Charlotte Department of Transportation

Memorandum

Subject: Rezoning Petition 08-070: Located in the block bounded by North Davidson Street, East 26th Street, East 27th Street & Yadkin Avenue (revised 9/8/08)

DATE: January 3, 2008
 DESIGNED BY: CCM
 DRAWN BY: SK
 CHECKED BY: CCM
 O.C. BY: CCM
 SCALE: 1" = 40'
 PROJECT #: 1007324
 SHEET #:
RZ-1.0

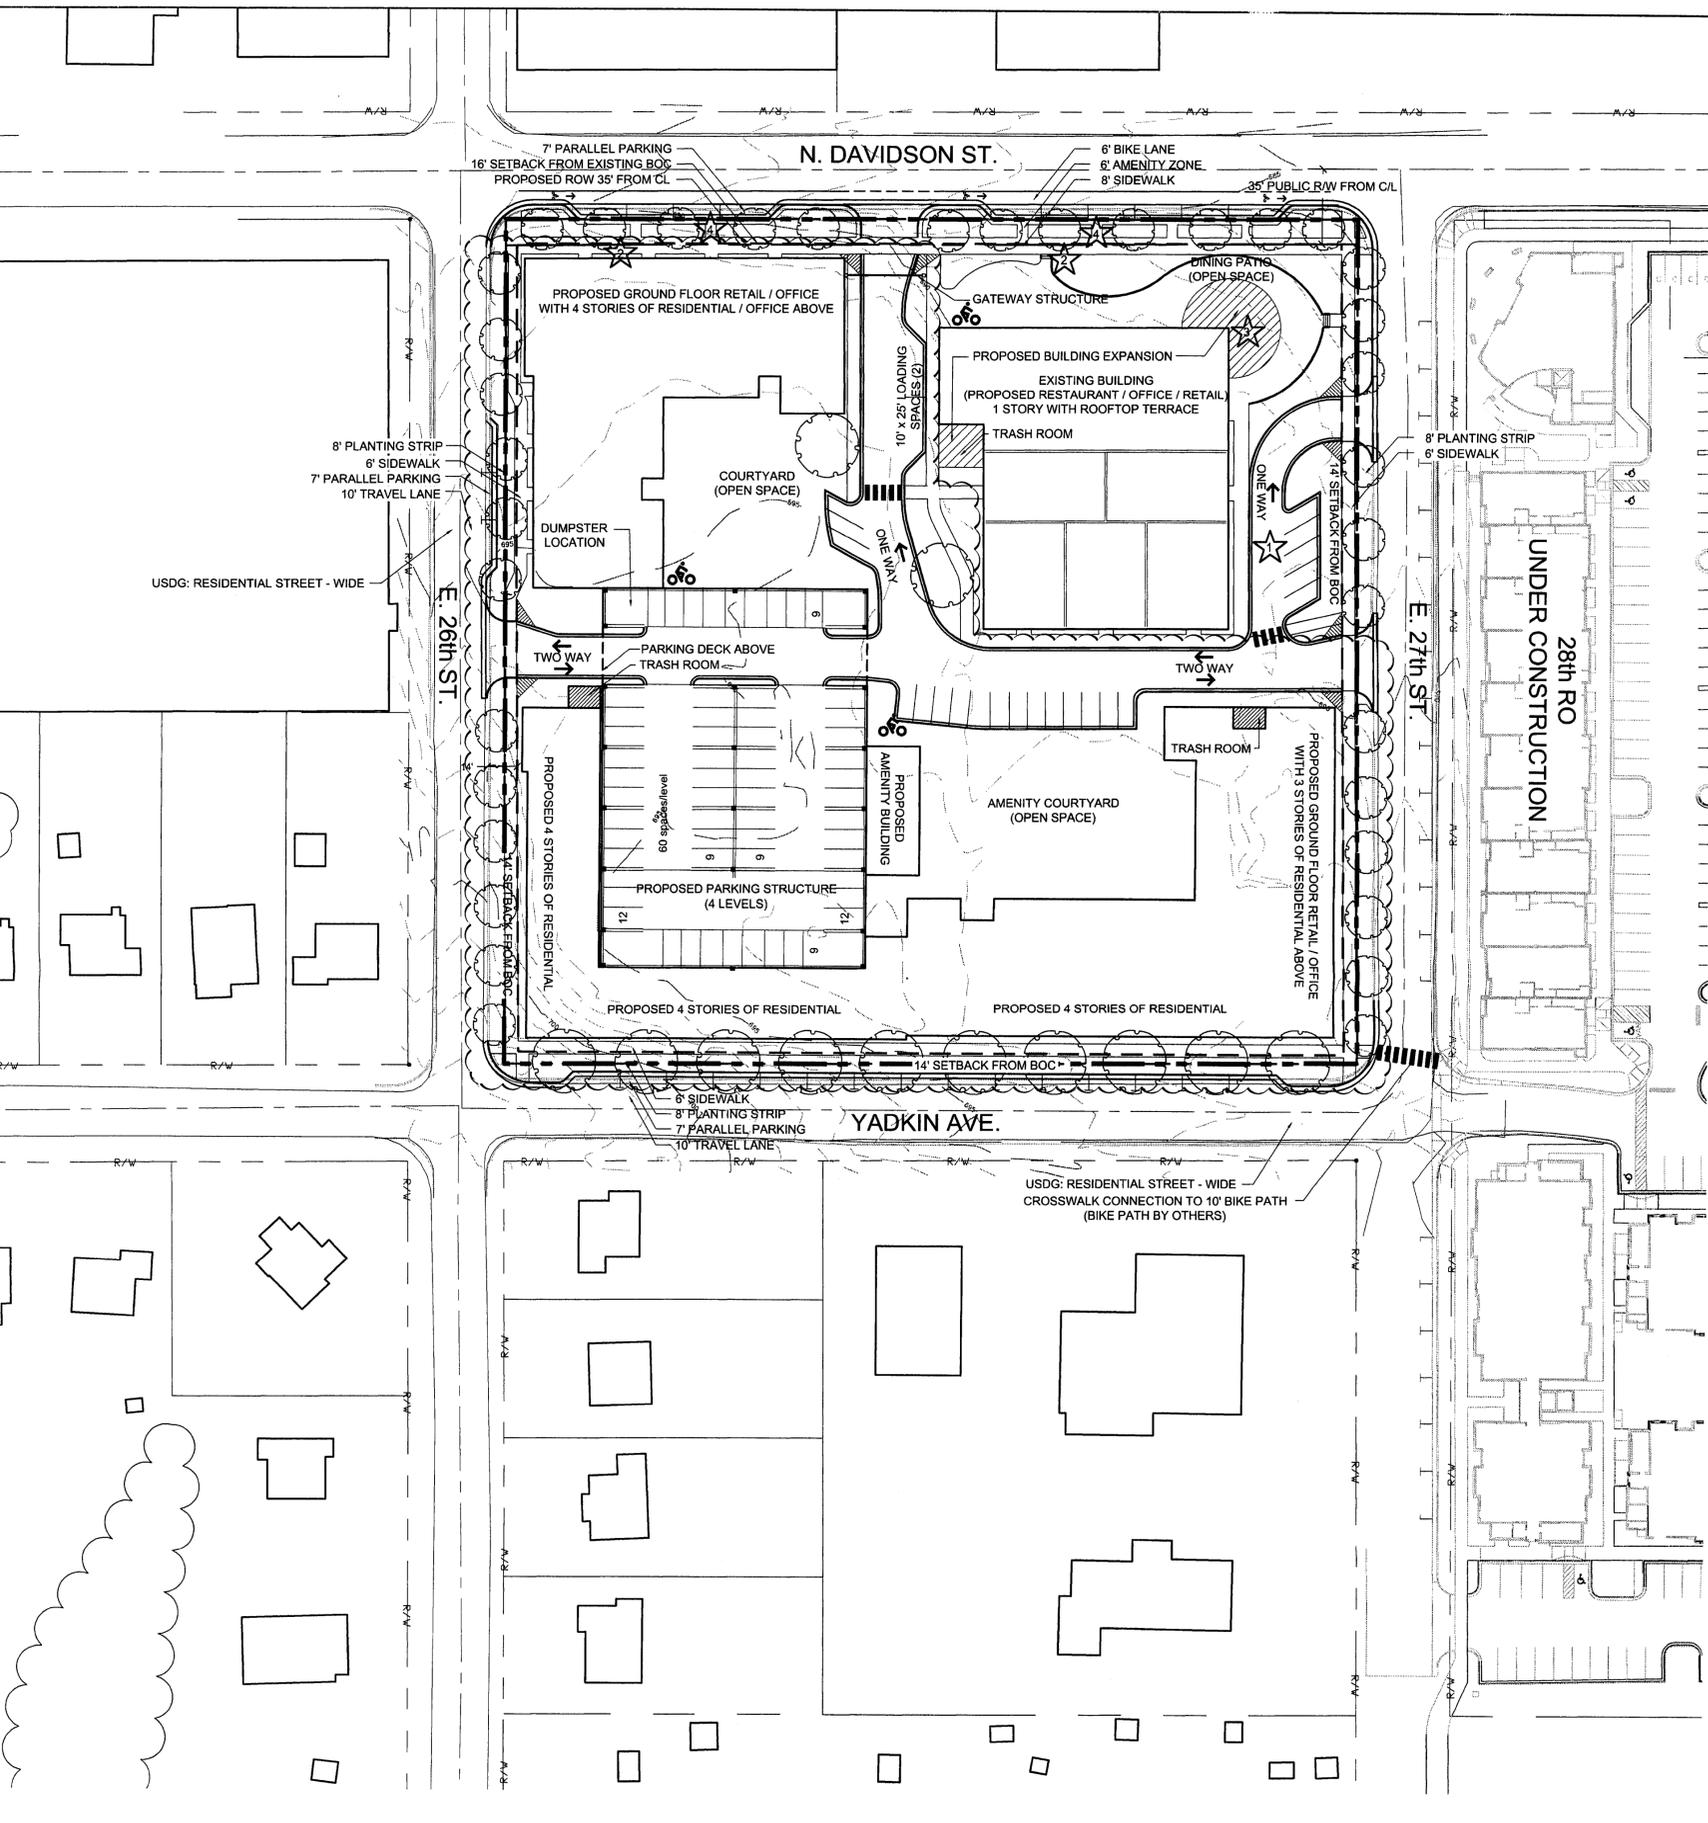
1. As shown on the site plan, access to the dumpster by waste collection vehicles is blocked by parking spaces. The site plan needs to be revised to show unimpeded access.
